Hansen Glebe Island Submission

Figure 16 Proposed layout of the Glebe Island Concrete Batching Plant

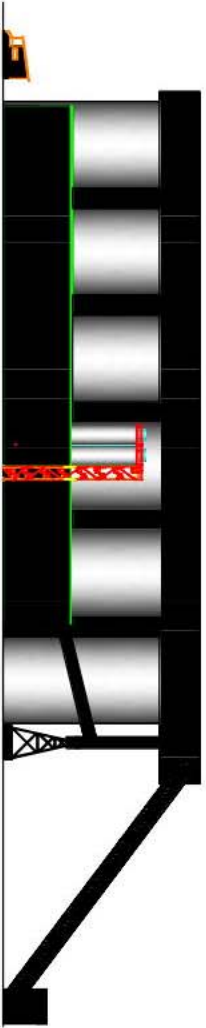
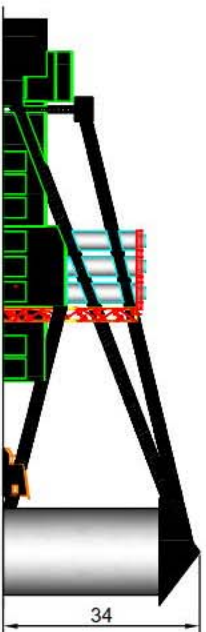
The claim that structures as high as 35m fit into the existing landscape is not supported. NSW DPE has produced a guideline for the siting of wind turbines and this document, if applied sympathetically towards the Hansen proposal, would reach the conclusion that the project must be redesigned or relocated. The large height buildings and silos are out of character with the landscape and cannot be claimed to be consistent with the heritage silos. The proposed new silos are not consistent with nearby heritage silos. The option of proposing silos of much lower height or fewer silos has not been considered in the EIS. The option to reduce the throughput of materials has not been explored and this would enable fewer and/or lower height silos. It may be that the site is undersized for the proposed throughput. The proponent has failed to include other options and this is an essential requirement of the EIS documentation.
